Markup Summary

VR1819

OBERLE VACATION and REPLAT

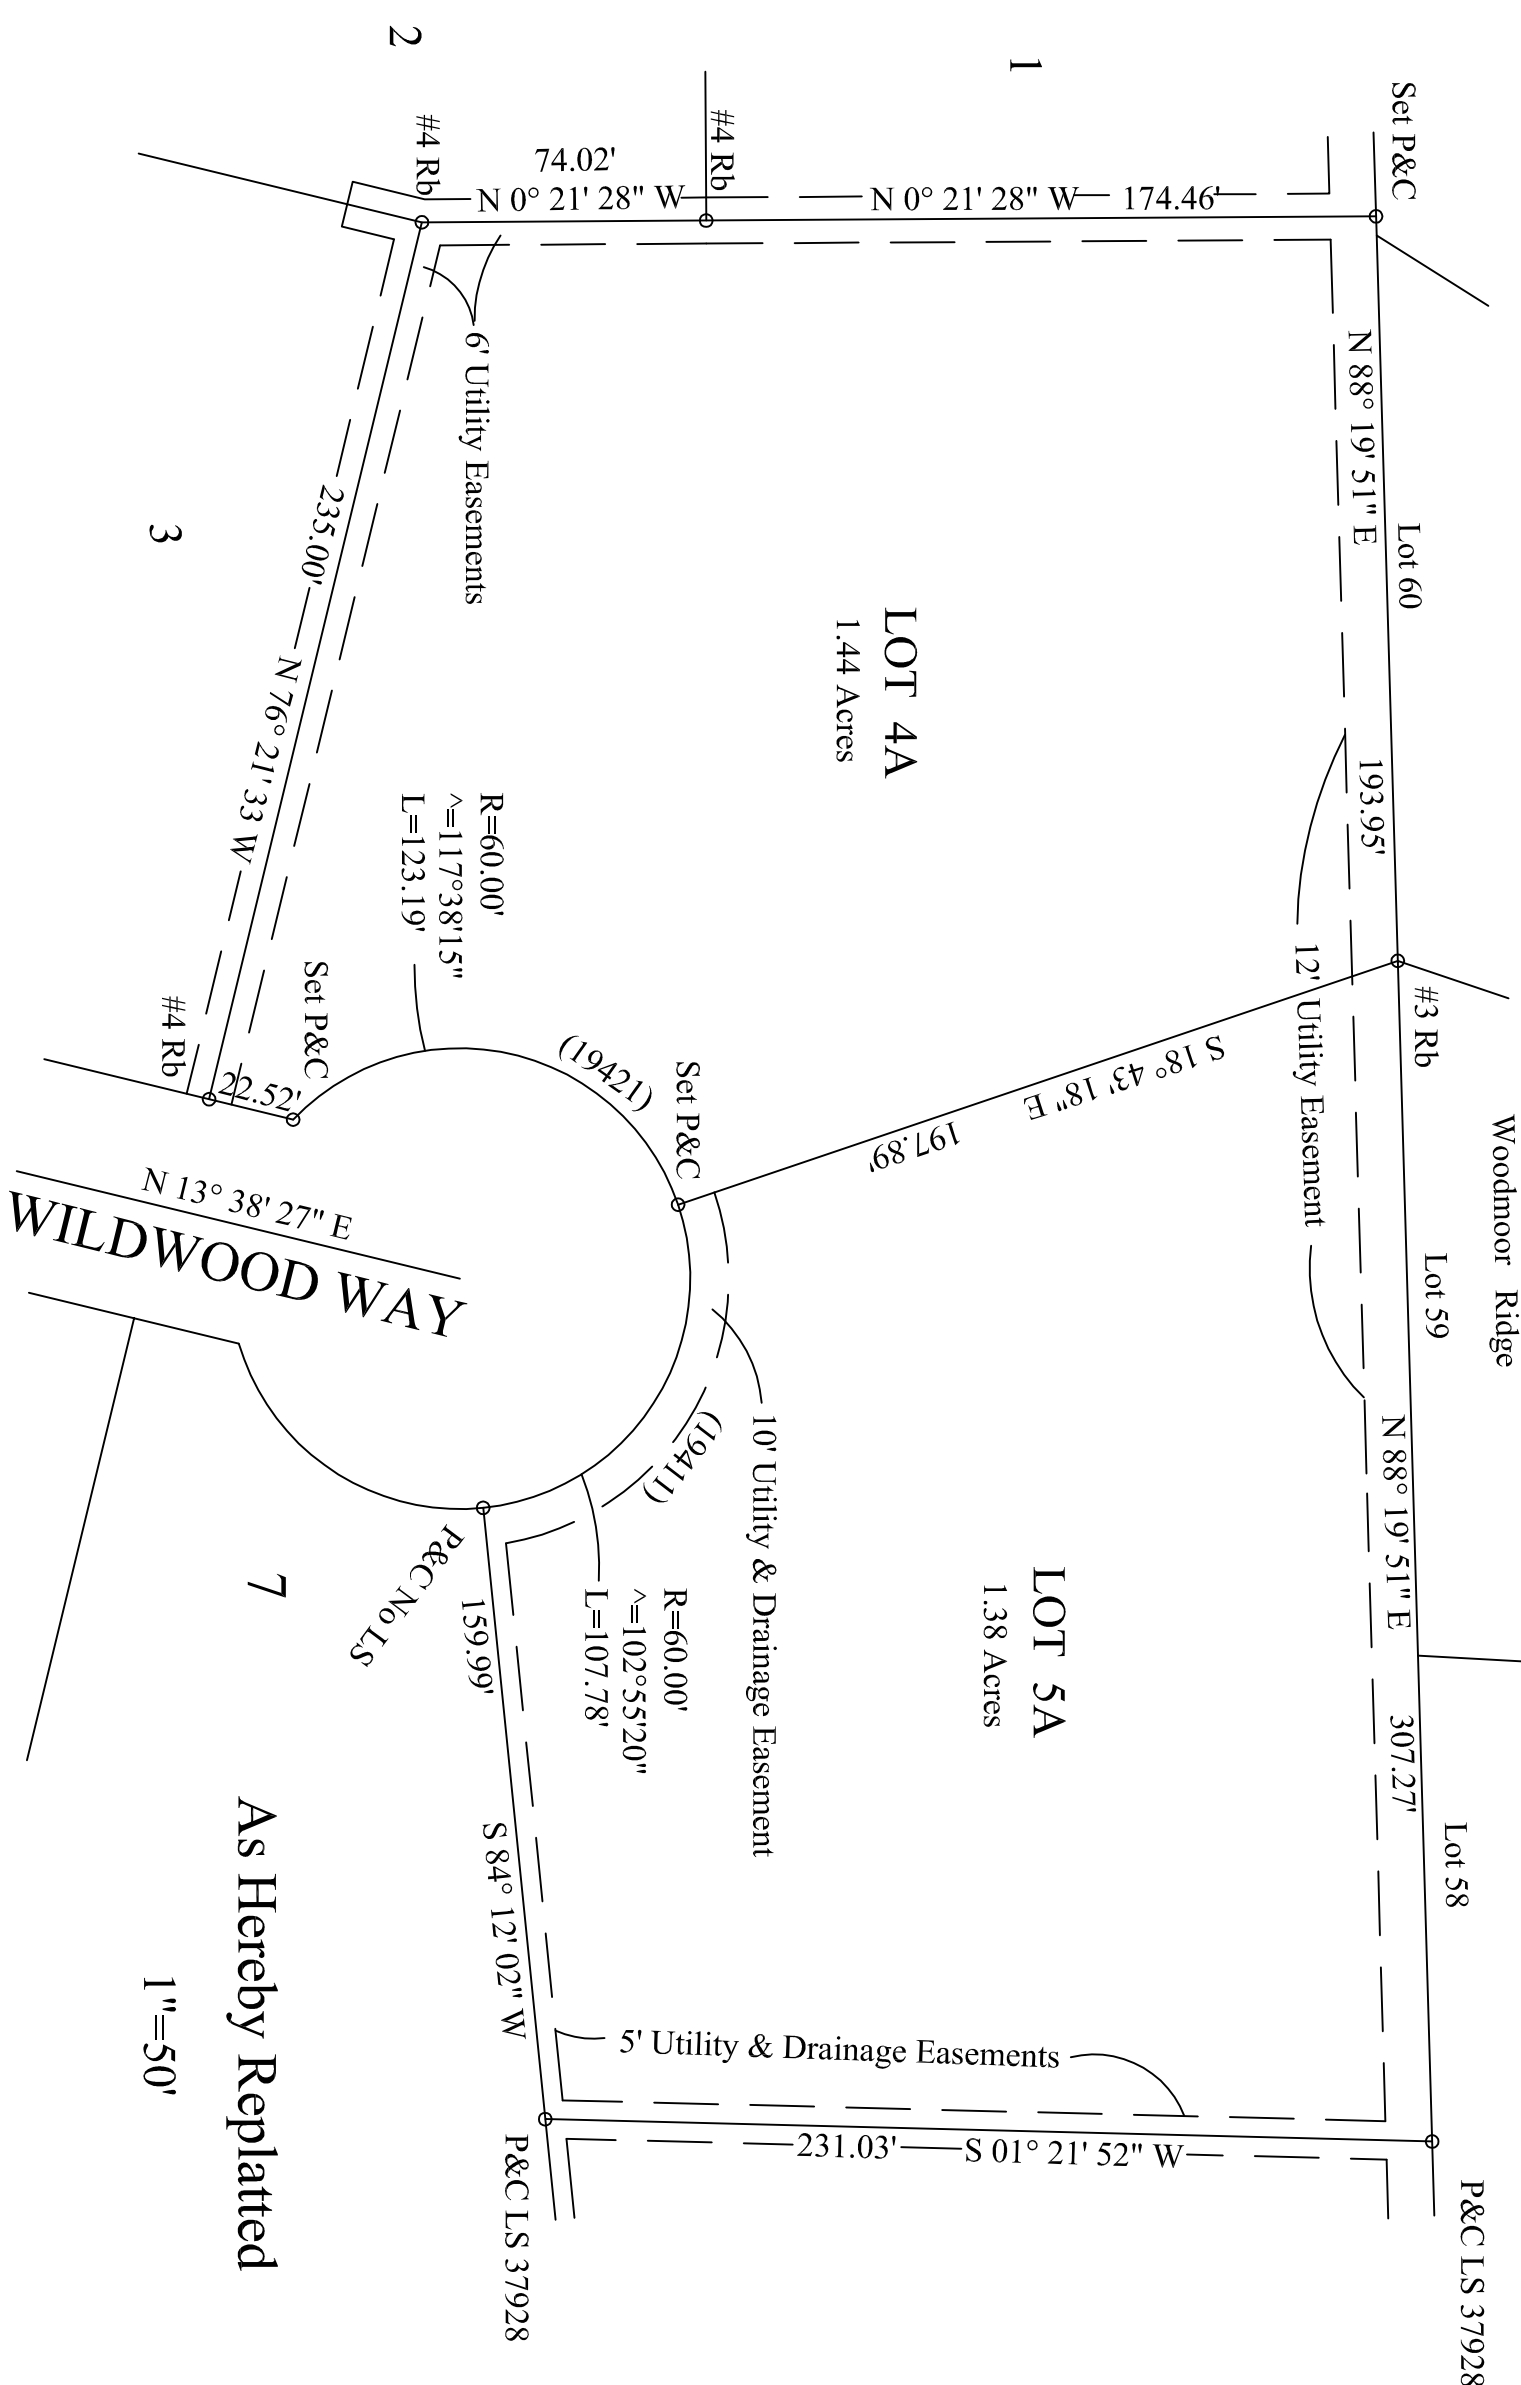
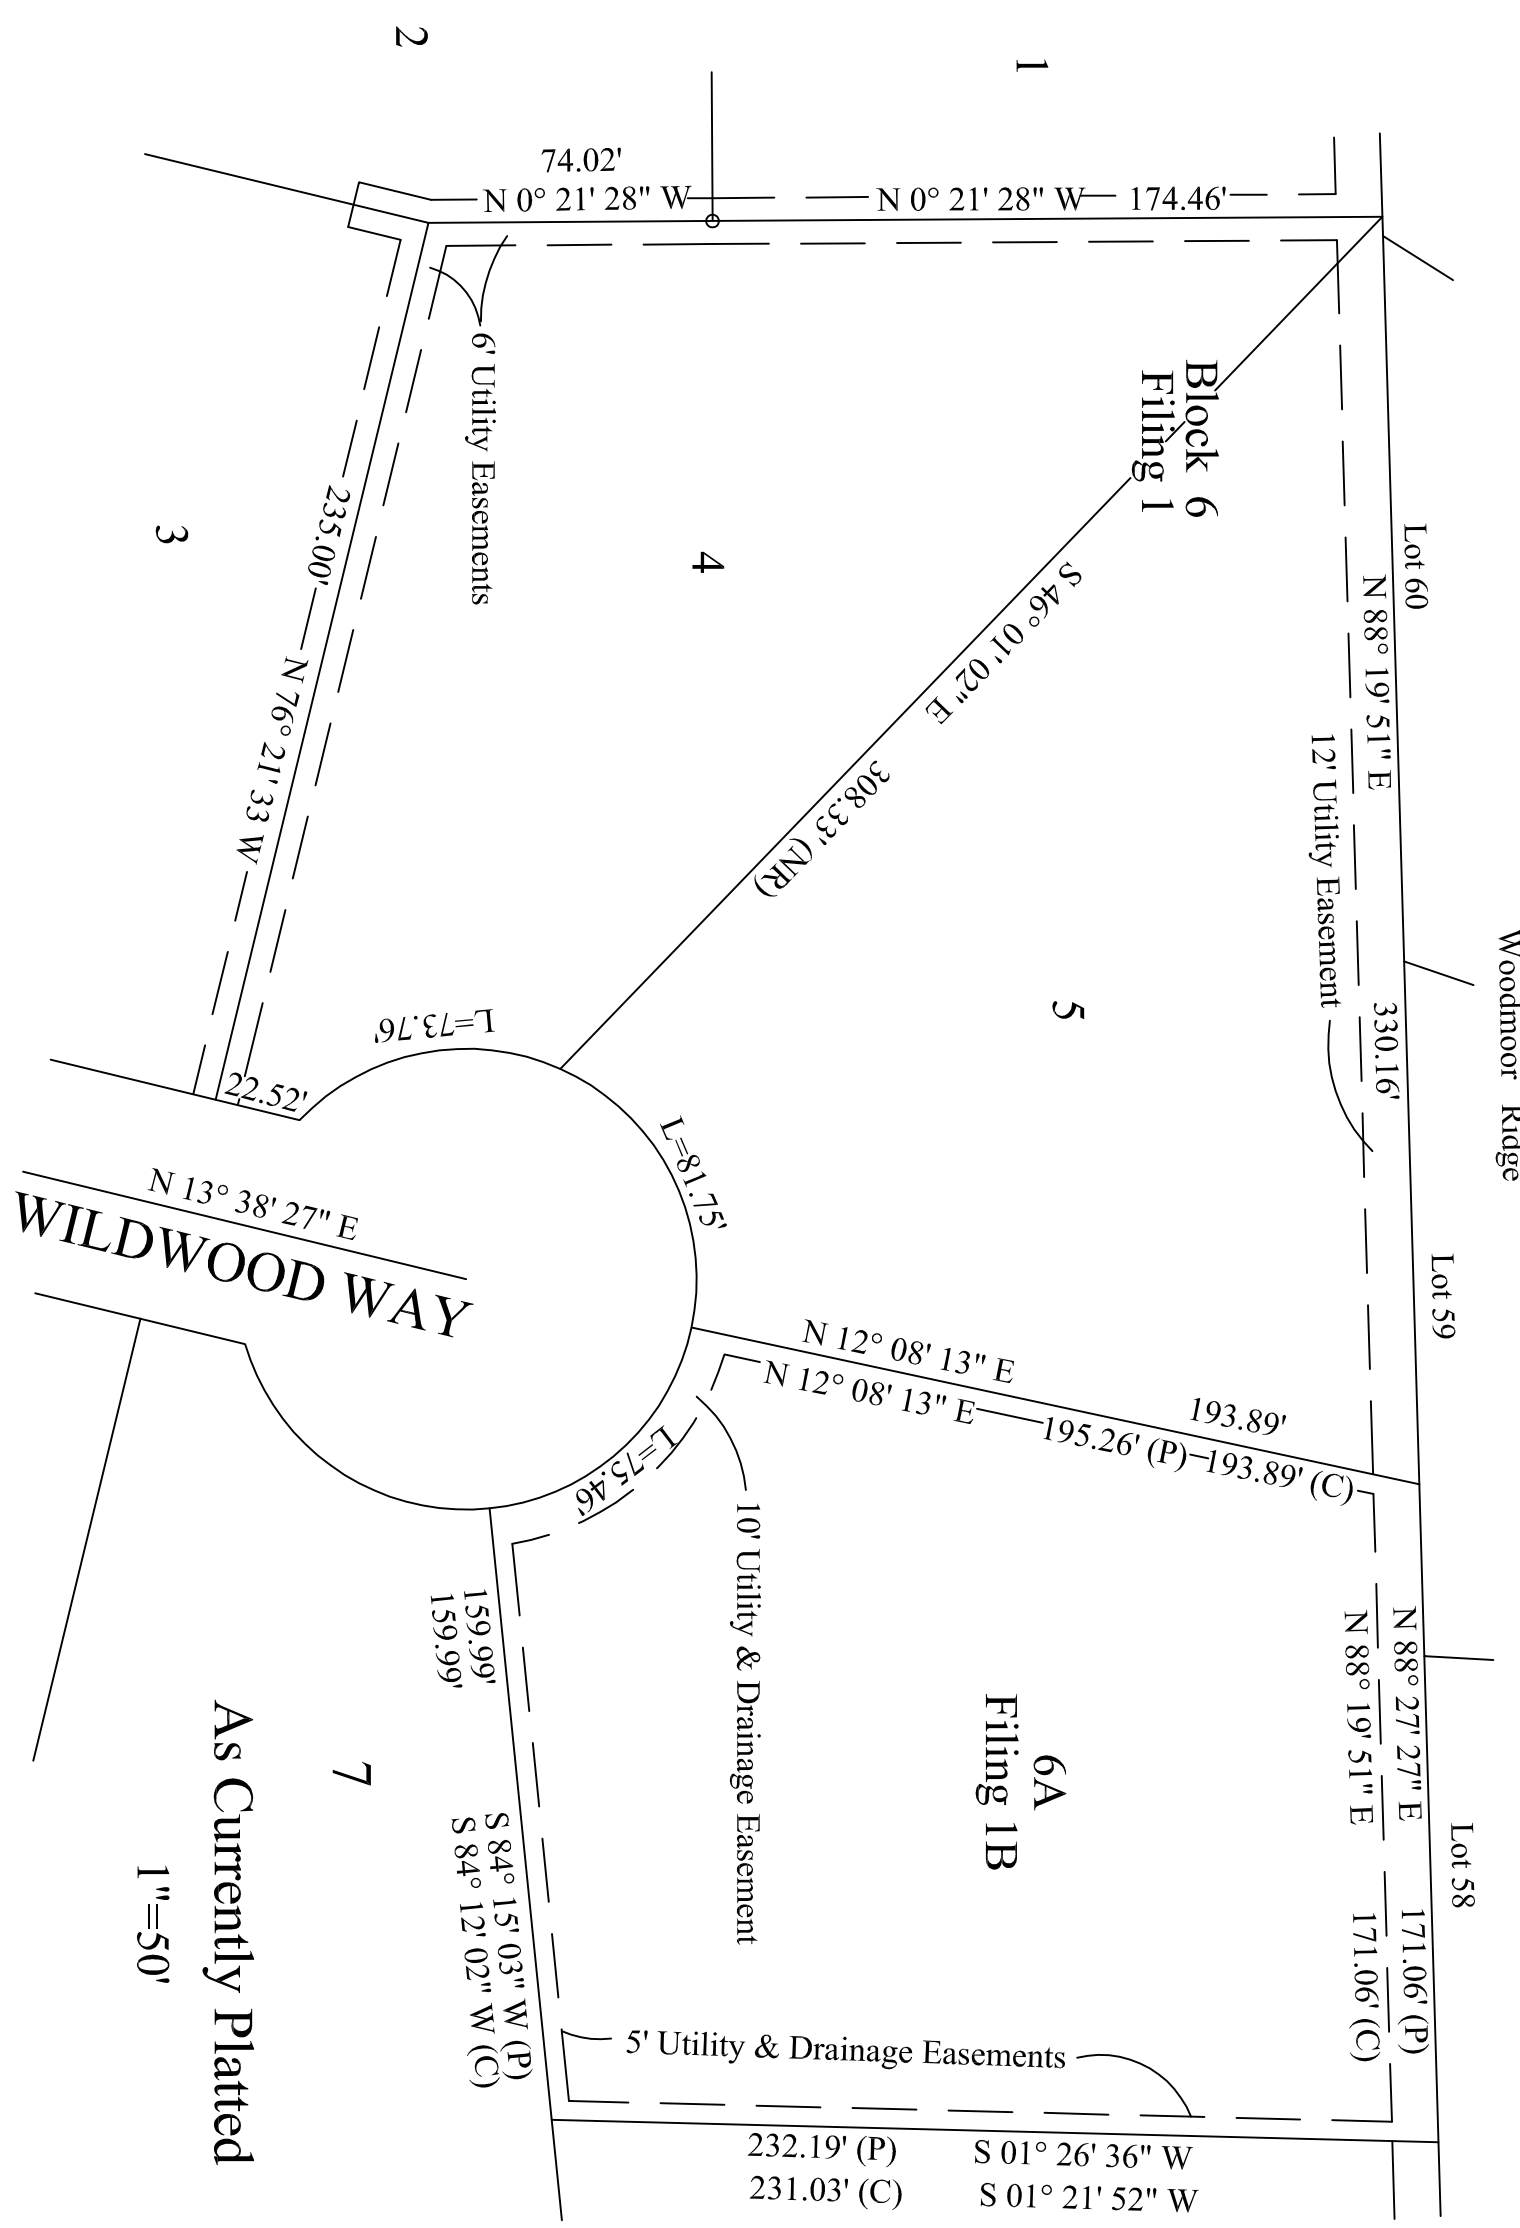
Update the FEMA FIRM number and reference to the December 2018 FIRM

Add the following note:
No driveway shall be established unless an access permit has been granted by El Paso County.

Additional Notes:

No driveway shall be established unless an access permit has been granted by El Paso County.

Approval of this replat vacates all prior plats for the area described by this replat.

Property may be subject to limitations, covenants

Include a note regarding water and wastewater

This is not needed.

These should be filled out

A replat of lots 4 and 5, Block 6,
Woodmoor Filing No. 1, and Lot 6A,
Woodmoor Filing No. 1B...in Section 11,
T 11 S, R 67 of the 6th P.M., El Paso
County Colorado.
